Mercure Hotel Heathrow, UB3

DAS Addendum

FOR
London Borough of Hillingdon

REFERENCE
24009

Ground Floor Plan  
Proposed

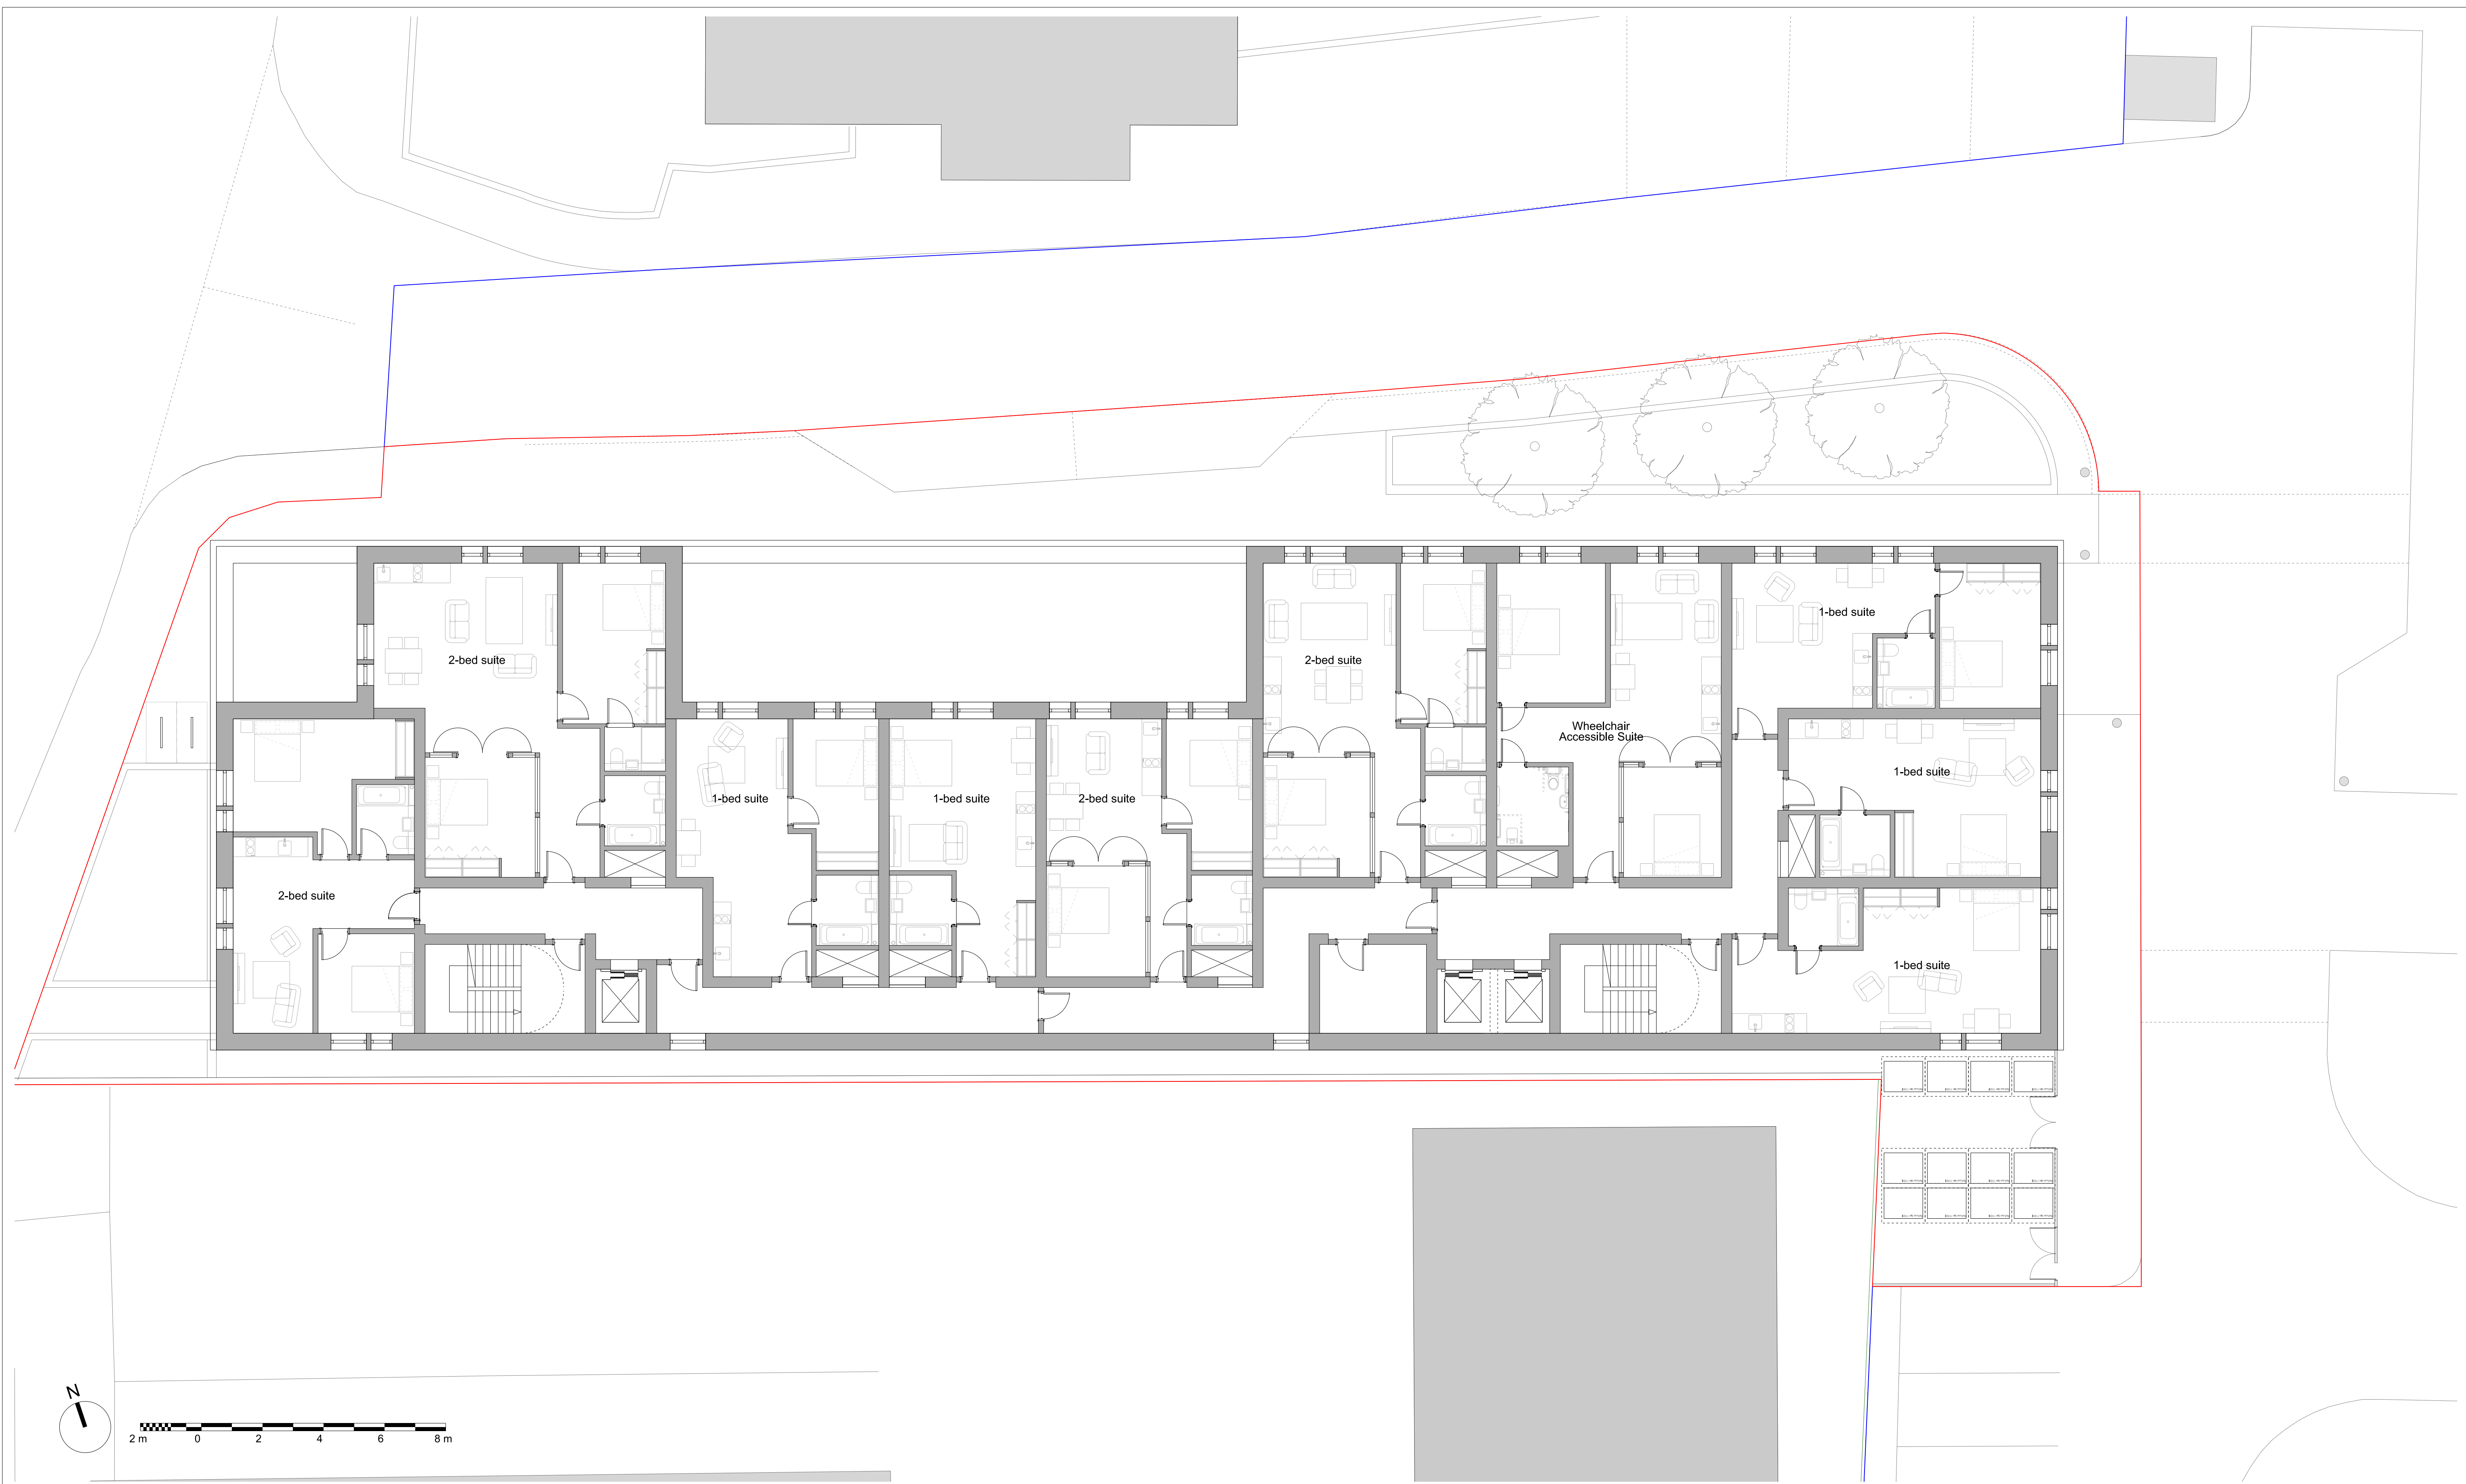
- Provide a coordinated landscaping strategy: Set out the proposed green infrastructure, including trees, planting
- Coordinate all landscape information: Reconcile the ground floor plan, CGIs and DAS so they show the same agreed tree and planting proposals

- Increase forecourt tree provision: Provide at least one large-canopy tree (potentially two depending on species), designed to reach maturity
- Provide adequate tree soil volume: Allow at least 25–30m³ of soil per large-canopy tree, with the arrangement shown on plan and coordinated with utilities, foundations, visibility splays and other constraints

- Add planting along Arlington Court: Introduce low-level/linear planting along the façade to soften the building frontage and the basement vent areas
- Demonstrate street-tree delivery: Show how the proposed street trees can be accommodated and grow to maturity, including underground infrastructure/soil provision

- Improve the ground-floor frontage: Retain the proposed hit-and-miss brickwork to the basement vents and add buffer planting to soften the raised/blank frontage
- Consider Juliet balconies: Add Juliet balconies to ground-floor windows facing Arlington Court, with screening/opacity to improve privacy and the appearance of the frontage

- One large-canopied forecourt tree, selected to provide meaningful canopy cover at maturity
- One compact street tree suitable for the constrained urban environment
- Three small to medium-sized trees to the rear of the site
- Additional buffer planting along the Arlington Court frontage.
- Additional planting along the south elevation

- Buffer planting has been introduced along the Arlington Court frontage to soften the relationship between the building and the public realm while maintaining appropriate pedestrian route widths
- Juliet balconies have been incorporated to the ground-floor windows. The lower sections of the narrow windows are proposed with opaque glazing to improve privacy to the associated suites
